The following submission contains my firm **objection**, to the **SSD – 9409987 Moss Vale Plastics Recycling Facility**

RE: SSD - 9409987 Moss Vale Plastics Recycling Facility

Figure 6.6 Proposed Haulage routes to and from the of the site (19m GML and CML vehicles)

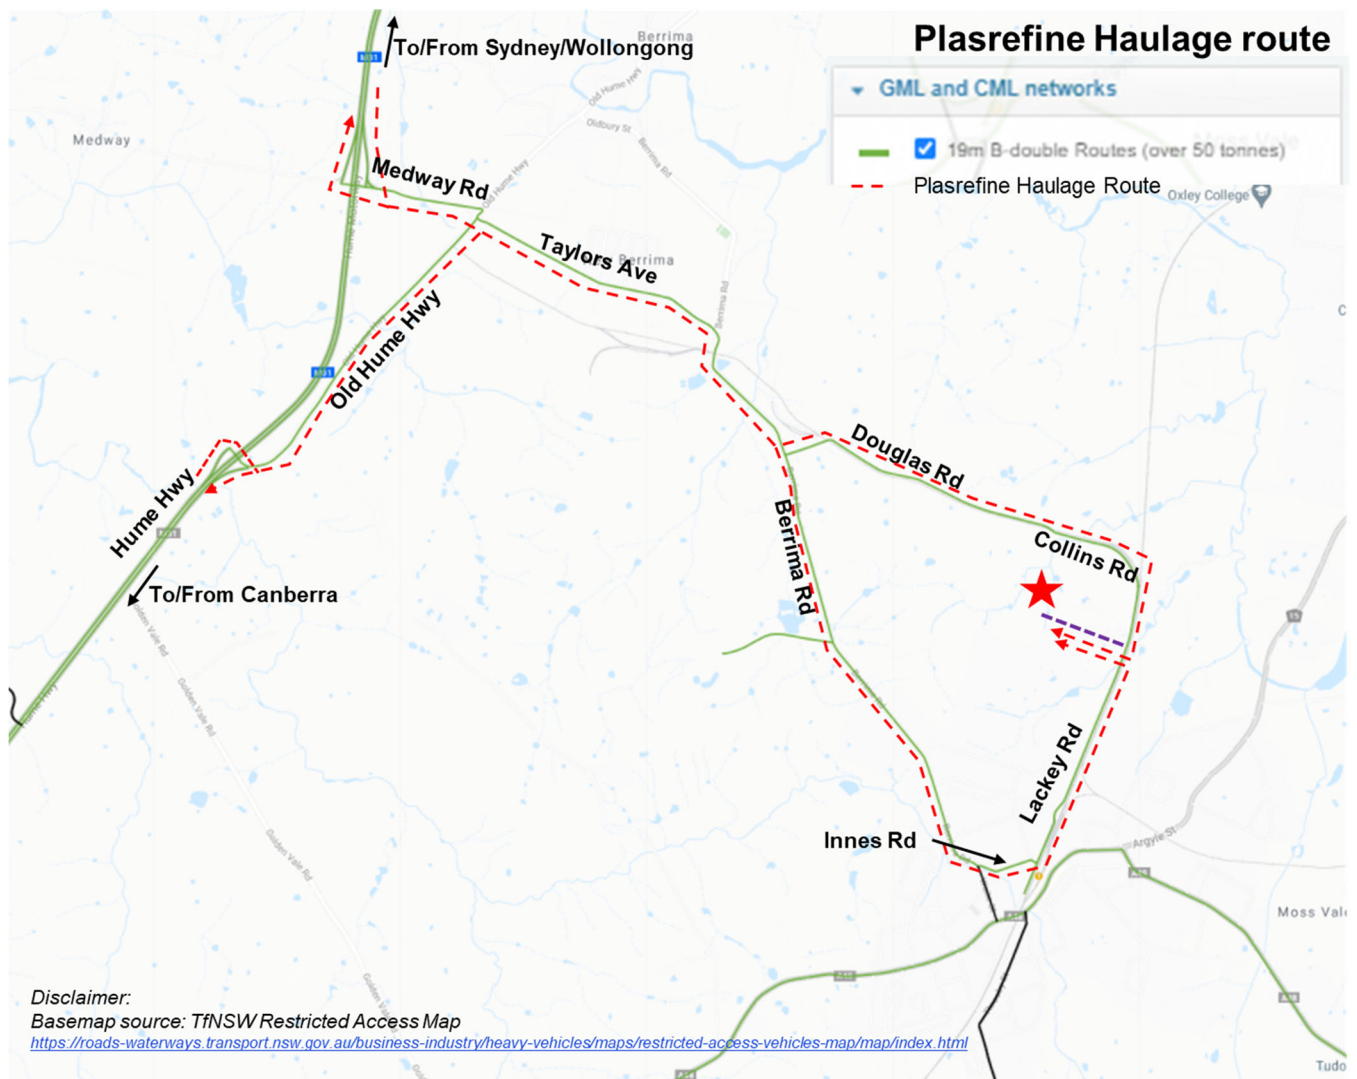
- Measurements taken by GHD on private property, to gauge the true height of the facility for concept drawing purposes, were conveniently positioned at the lowest possible point on the property. Therefore, the true height and landscape impact of the buildings, is unknown

- No detailed architectural drawings of buildings, no contour plan, no survey plan, no cut and fill plans, no provision for a suitable buffer zone between site buildings and residential homes, nor the Garvan Institute
